CITY OF ALBUQUERQUE

Re: Roper Warehouse
115 Texas NE
Approval of Permanent Certificate of Occupancy (C.O.)
Engineer's Stamp dated 04/15/2005 (K-19/D123)
Certification dated 1/12/2007

**Re: Roper Warehouse, 115 Texas Street NE, Traffic Circulation Layout
Engineer's Stamp dated 1-07-05 (K19-D123)**

SHEET NO.
C-1

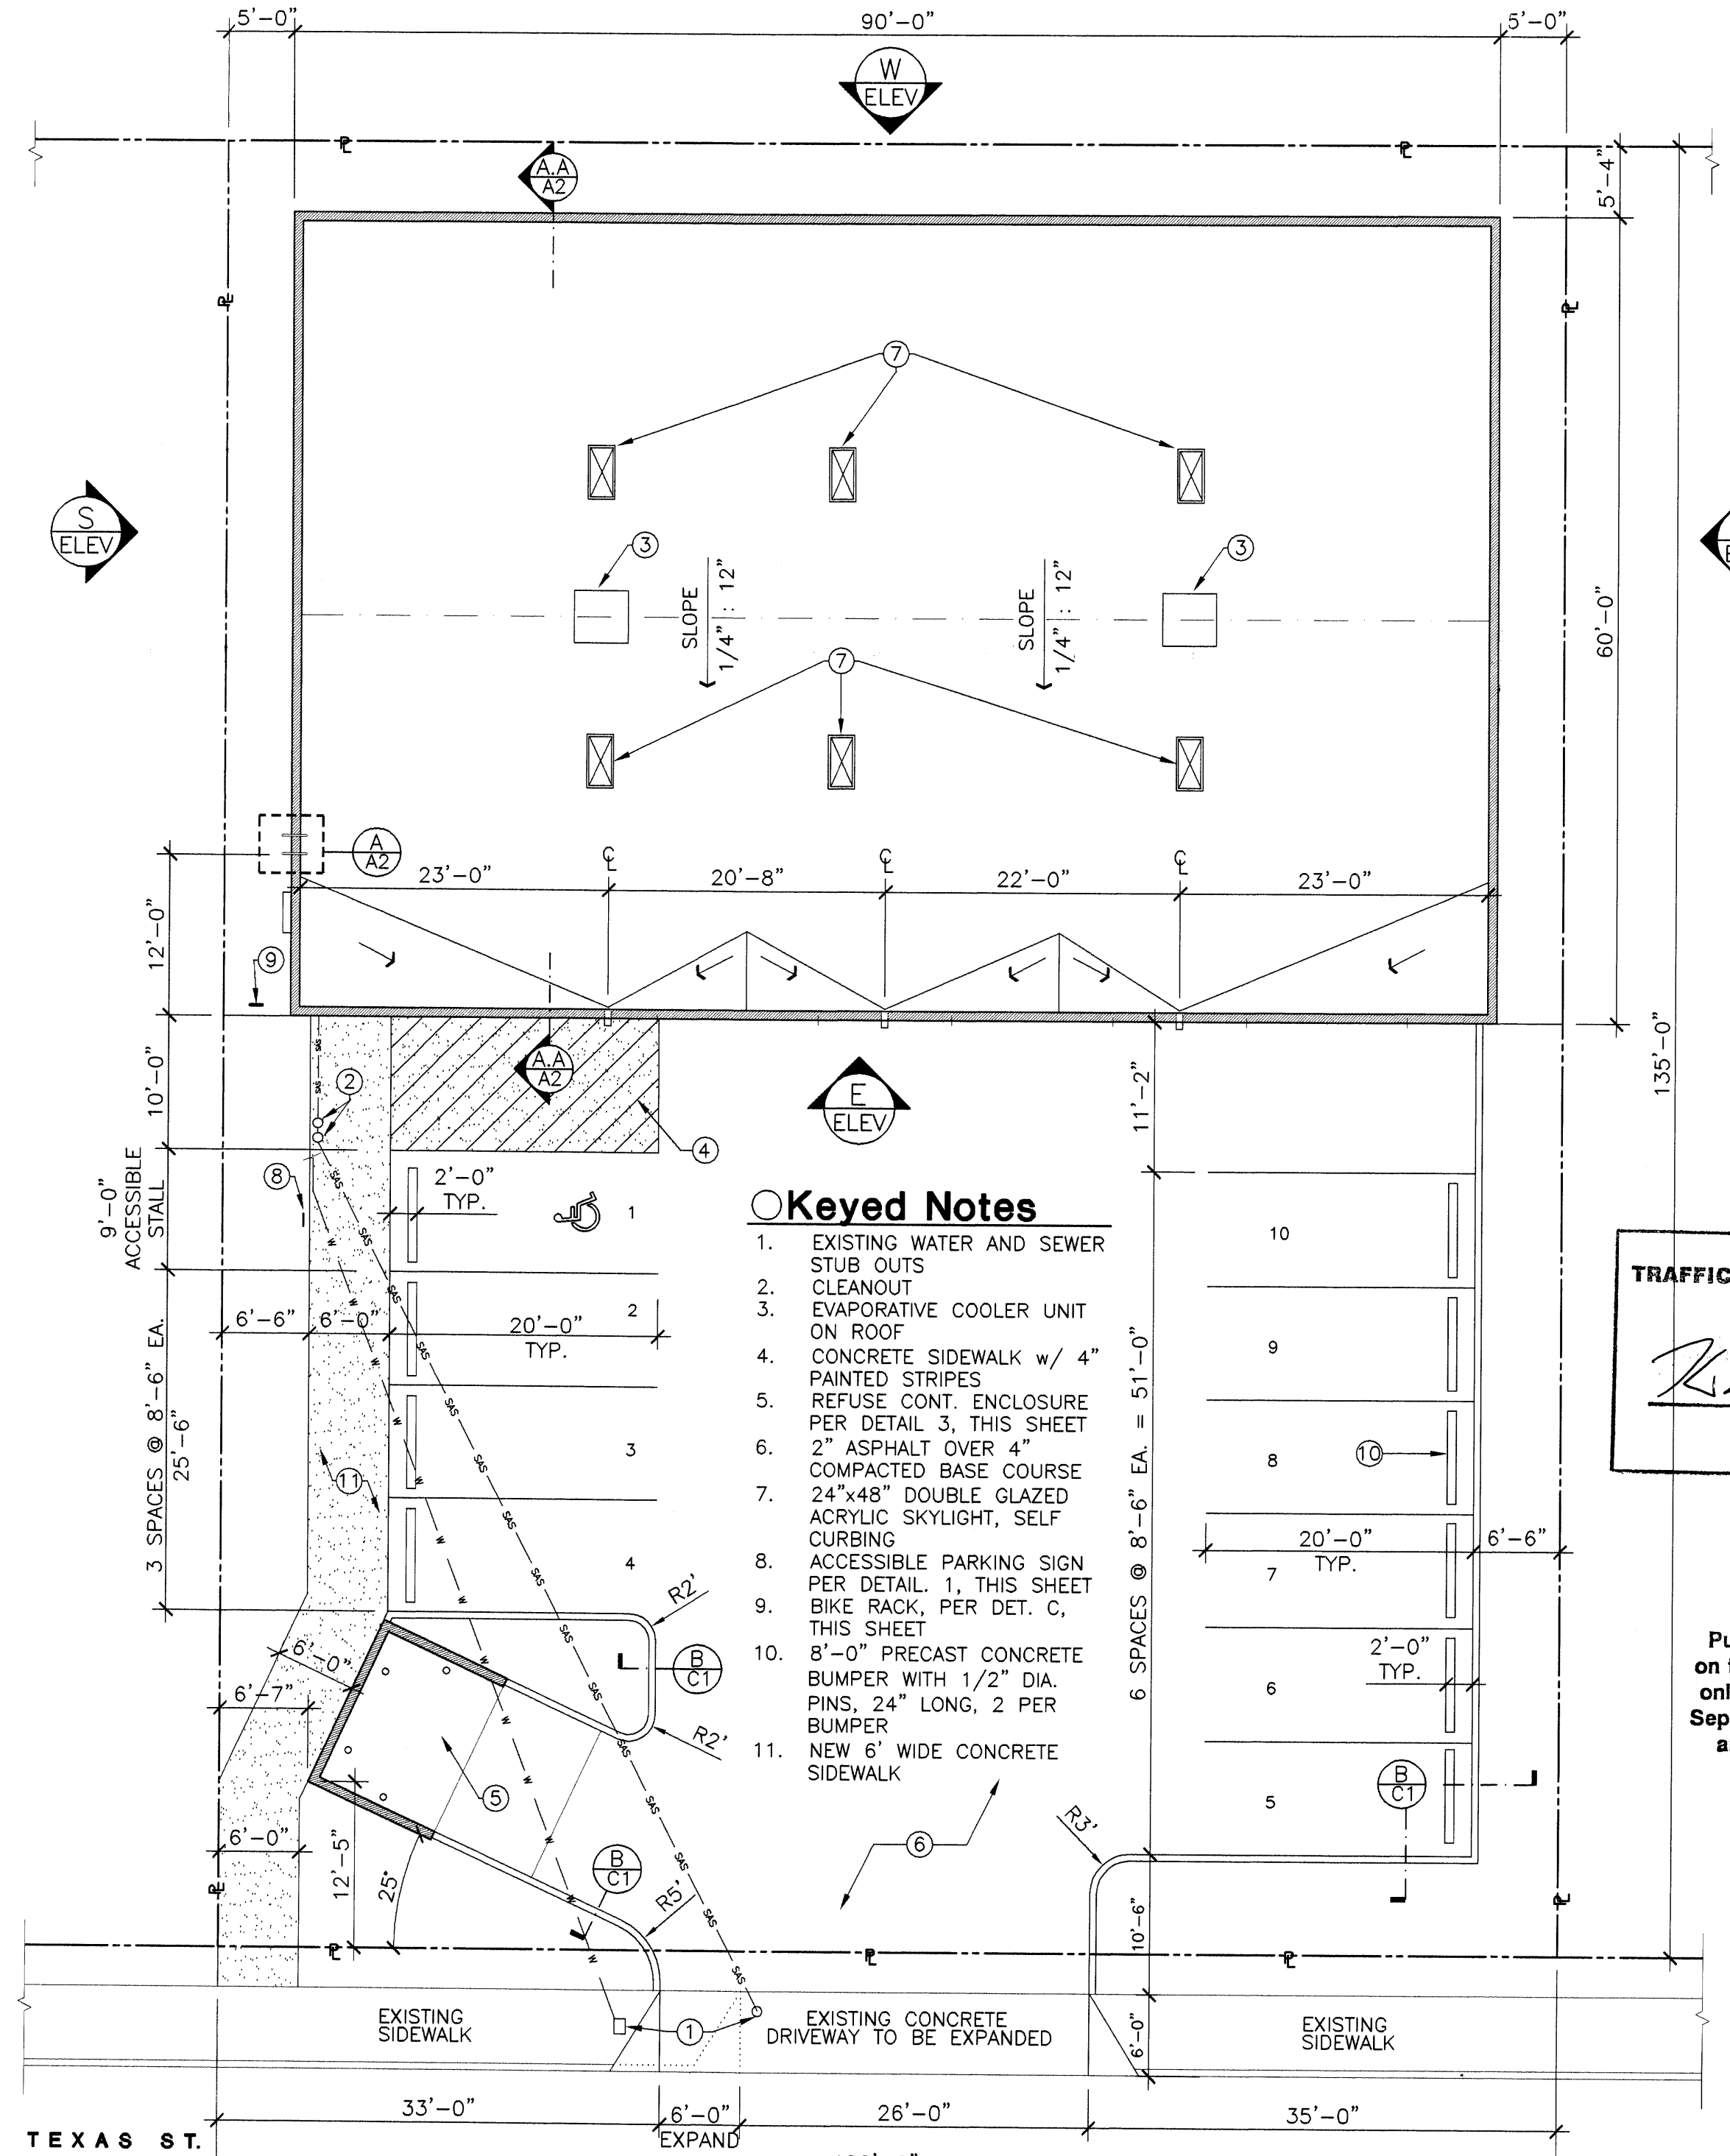
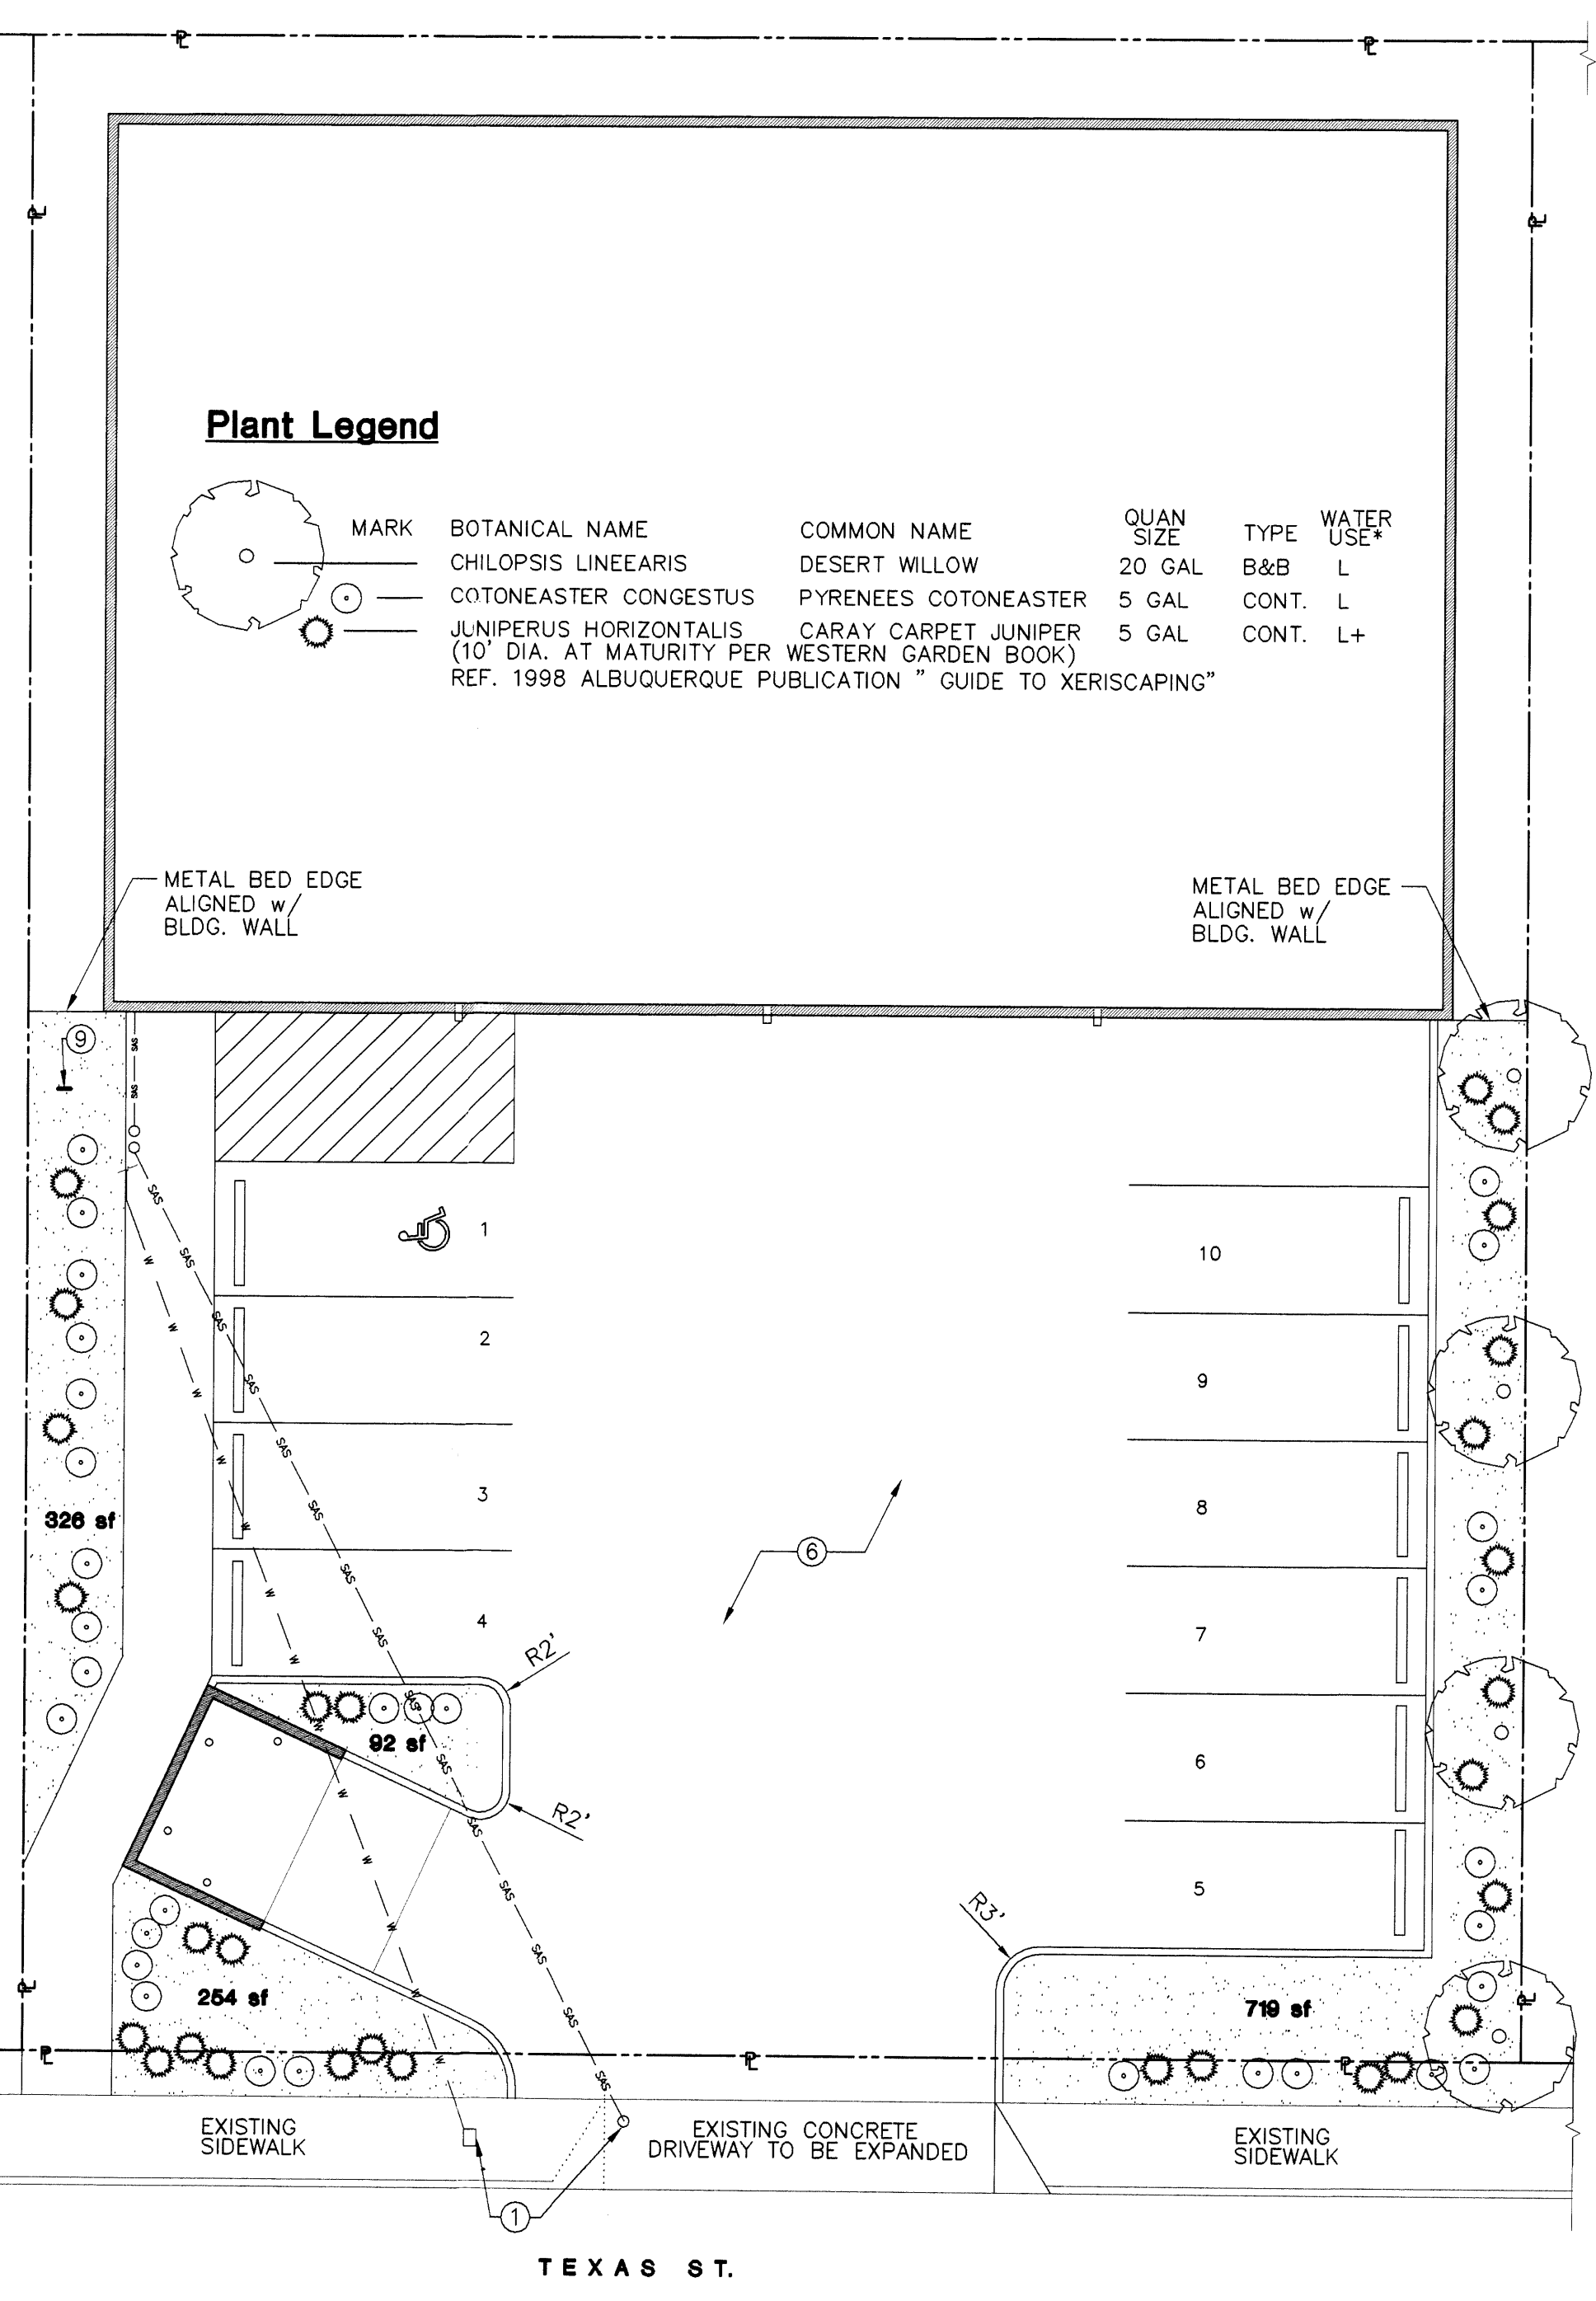
- ✓ 1. List the number of parking spaces required by the zoning code as well as the proposed number of parking spaces.
2. Has solid waste approved the positioning of the trash dumpster behind the gate?
- ✓ 3. Please list the width and length of the handicapped space and the van access aisle.
